East Anglia ONE North and East Anglia TWO Offshore Windfarms

Applicants' Comments Suffolk County Council's Deadline 8 Submissions

Document Reference: ExA.AS-6.D9.V1

Date: 15th April 2021

TITLE
THEBERTON MITIGATION SCHEME
(LINK 4b, B1122- Leiston Road) -
Preliminary Design

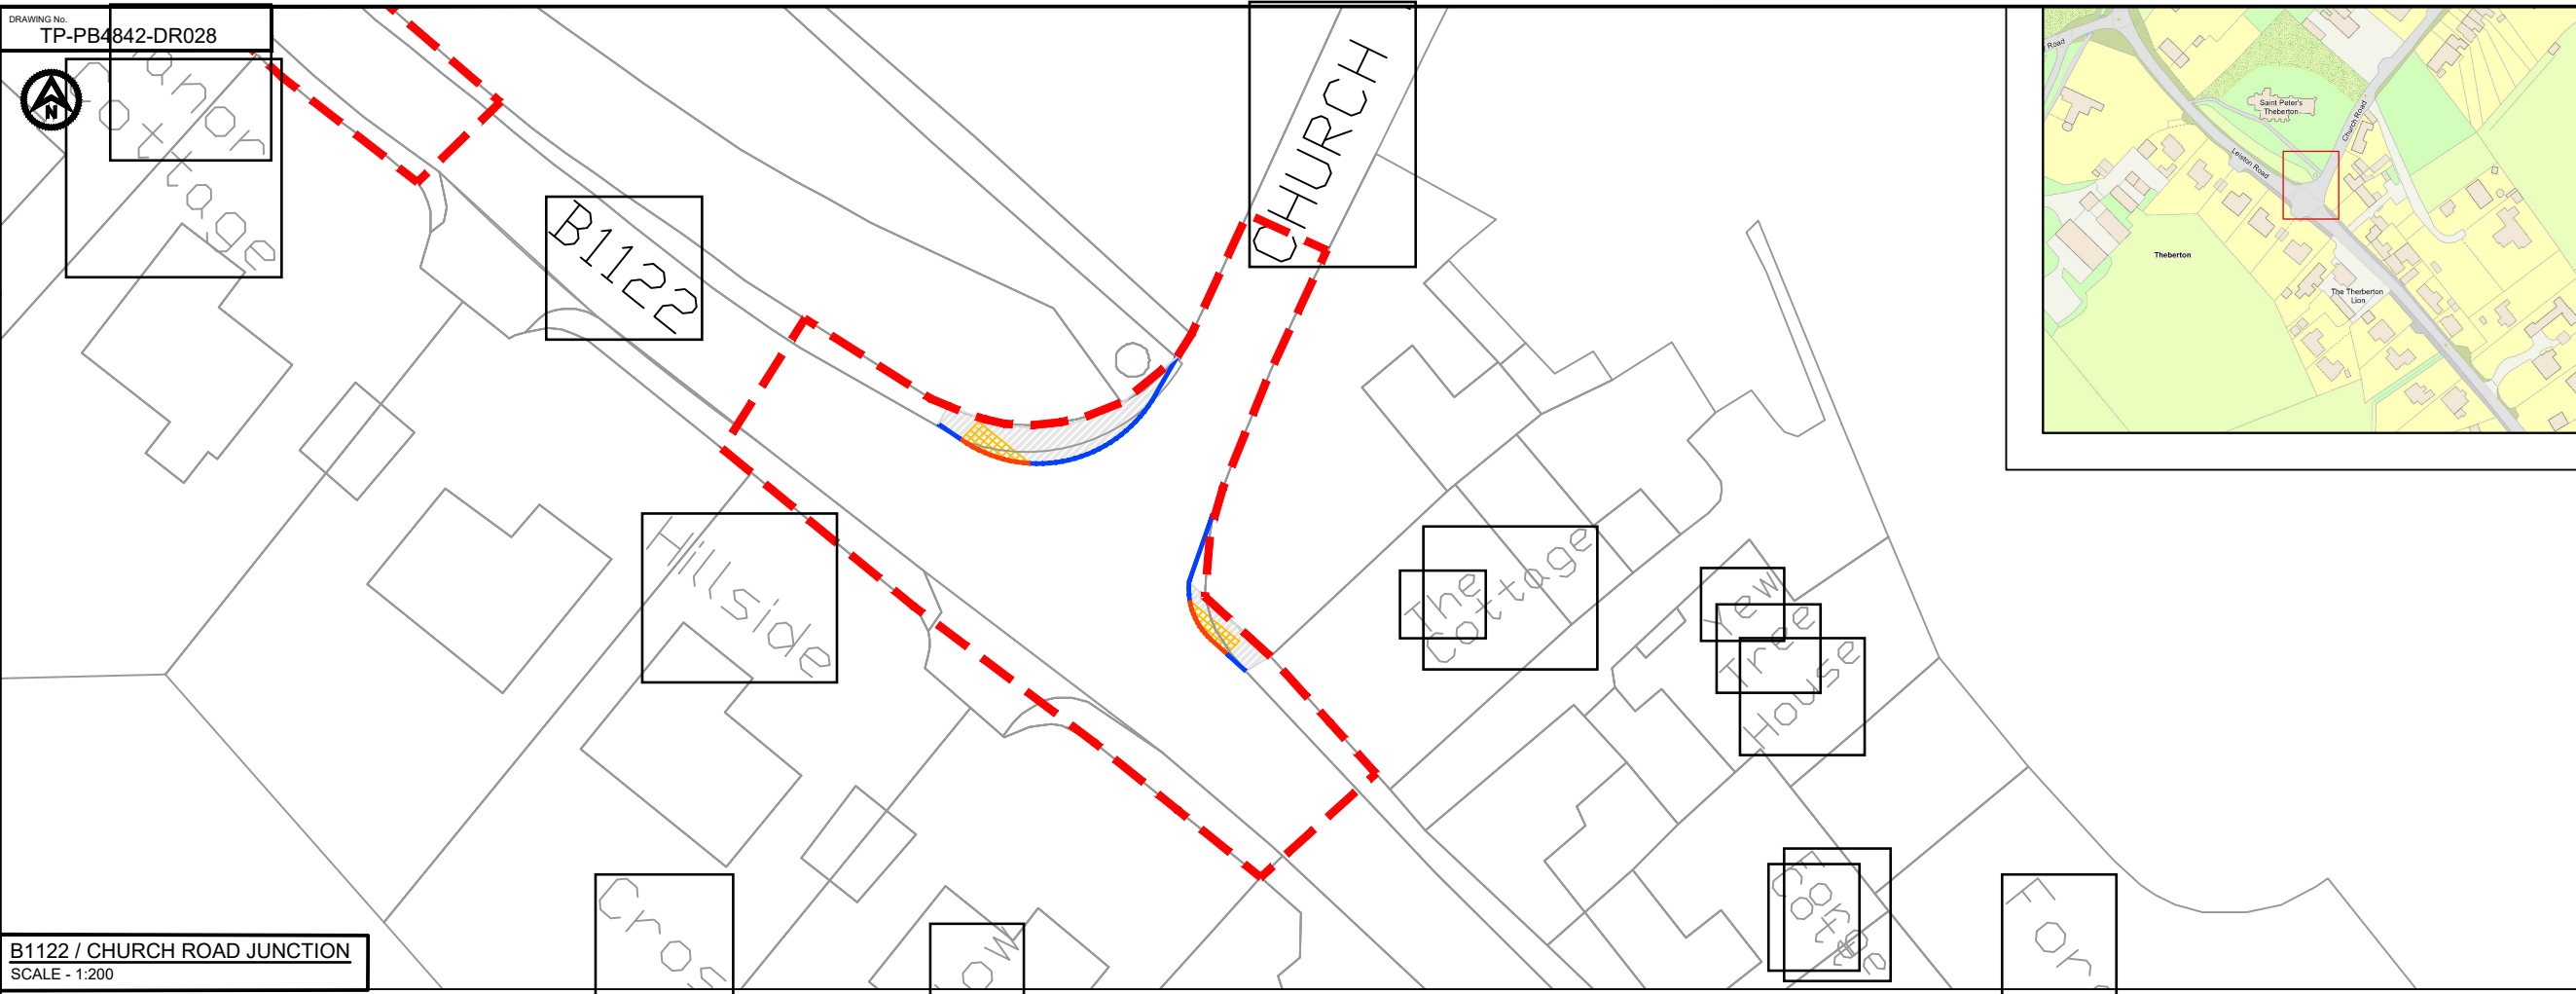
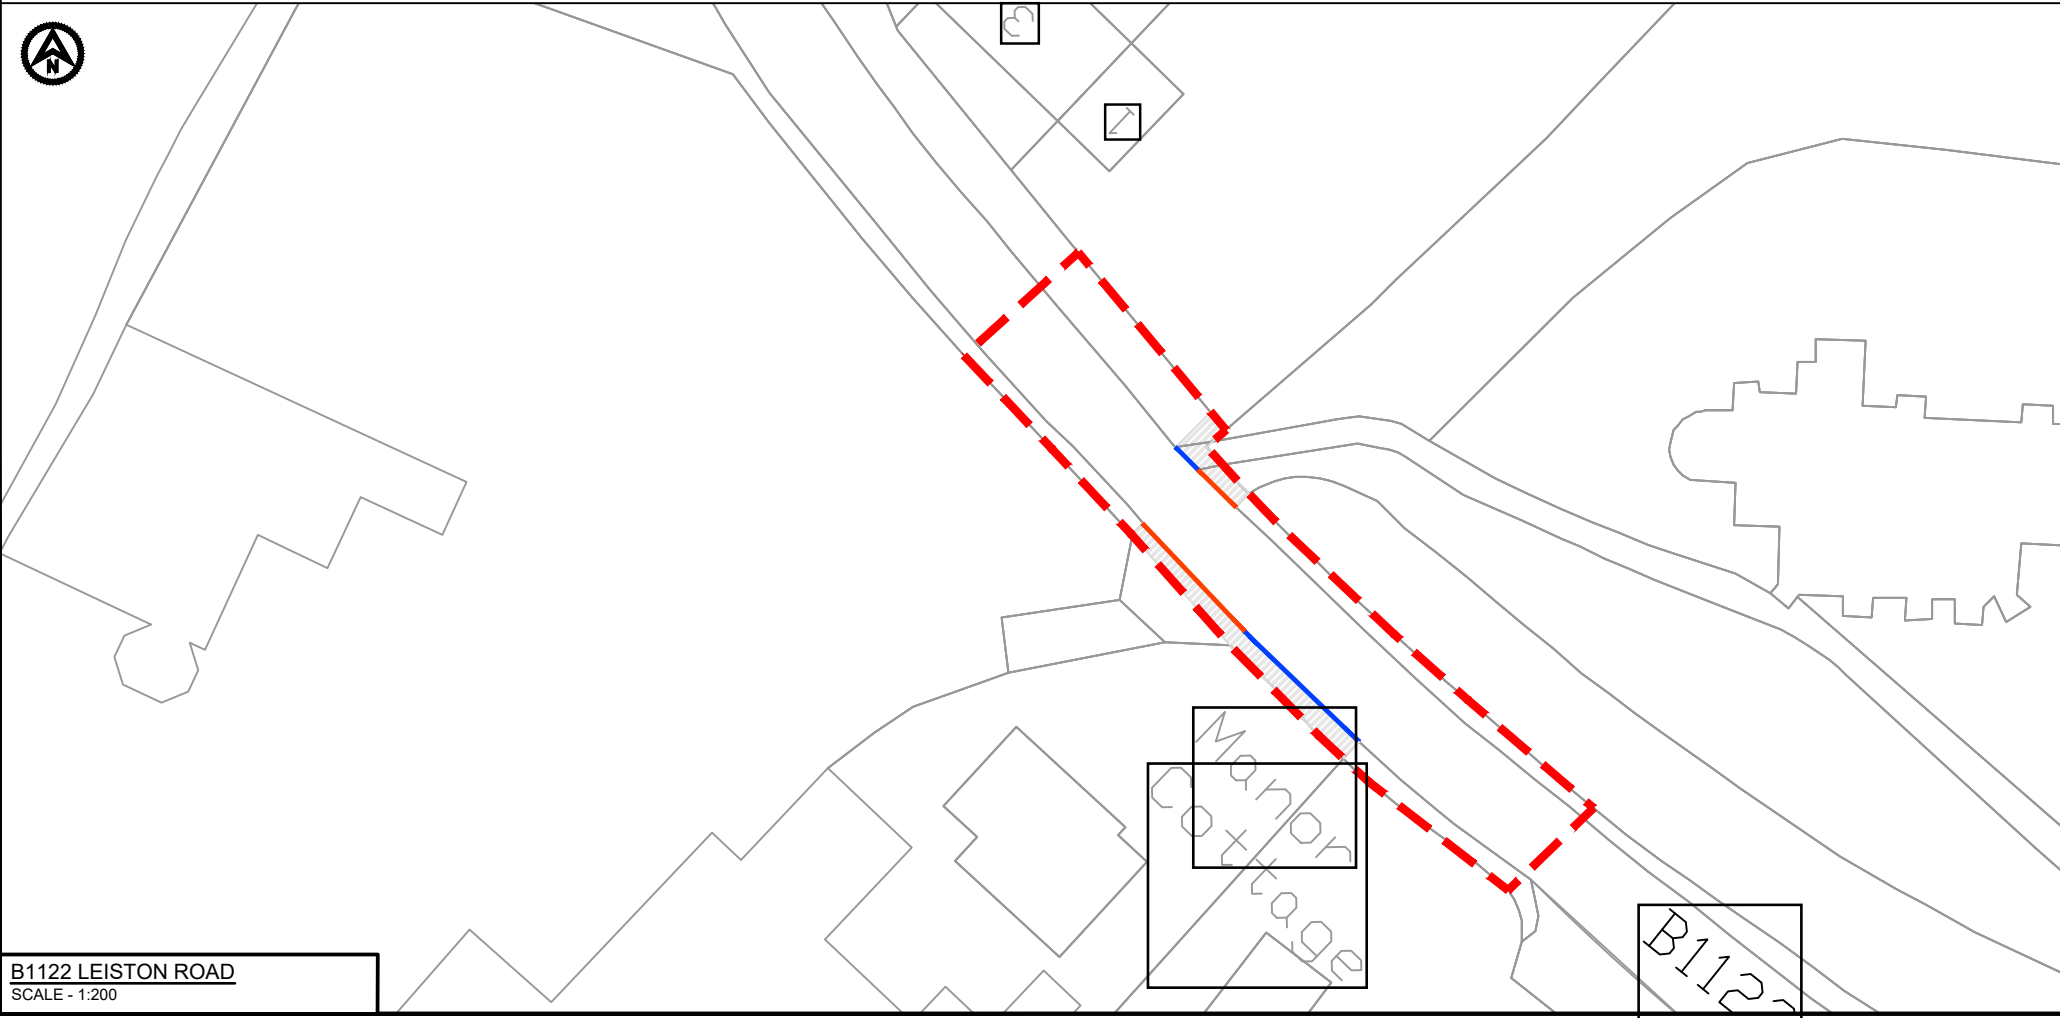
3	It was agreed that the applicant would submit the relevant details of the proposed works and that the Parochial Church Council will respond at Deadline 8 with their comments. Parochial Church Council Comments at D8: Whilst the PCC welcome the extension of the footpath west of the B1122, the visibility of the crossing point of the B1122 by Pretty Road is poor especially from East to West and should not be encouraged.	A key component of the S278 approval process would be an independent Road Safety Audit (RSA) undertaken by qualified road safety specialists to ensure that the designs are safe. Any RSA recommendations must be addressed to SCC's satisfaction prior to implementing a scheme. With regards to visibility at the crossing point of the B1122, this would be considered as part of the independent RSA. However, the mitigation measures seek to remove the requirement for pedestrians to walk in the road before

ID	SCC Comment	Applicants' Comments
	<p>The plan is not clear as to how much of the bank will be taken north of Church Road and we understand that detailed plans will follow which will show this.</p> <p>The PCC is concerned the effect this part of the proposed development might have on the stability of the wall and it's affect on the setting of the listed War Memorial.</p>	<p>crossing to the footway on its northern side to continue and promote perpendicular crossing to maximise visibility.</p> <p>With regards proposed Church Road footway works, these would involve the creation of a small area of footway which would largely be constructed within the existing road through a narrowing of the junction. Subject to a detailed topographical survey, there may be a requirement for a small area of the existing earth bank to also be used to construct the footway. Should that be the case, the Applicant will consult with SCC, East Suffolk Council and representatives from St. Peters Church to agree an appropriate solution that will ensure no impact on the structural integrity of the adjacent wall or compromise the War Memorial surroundings.</p>
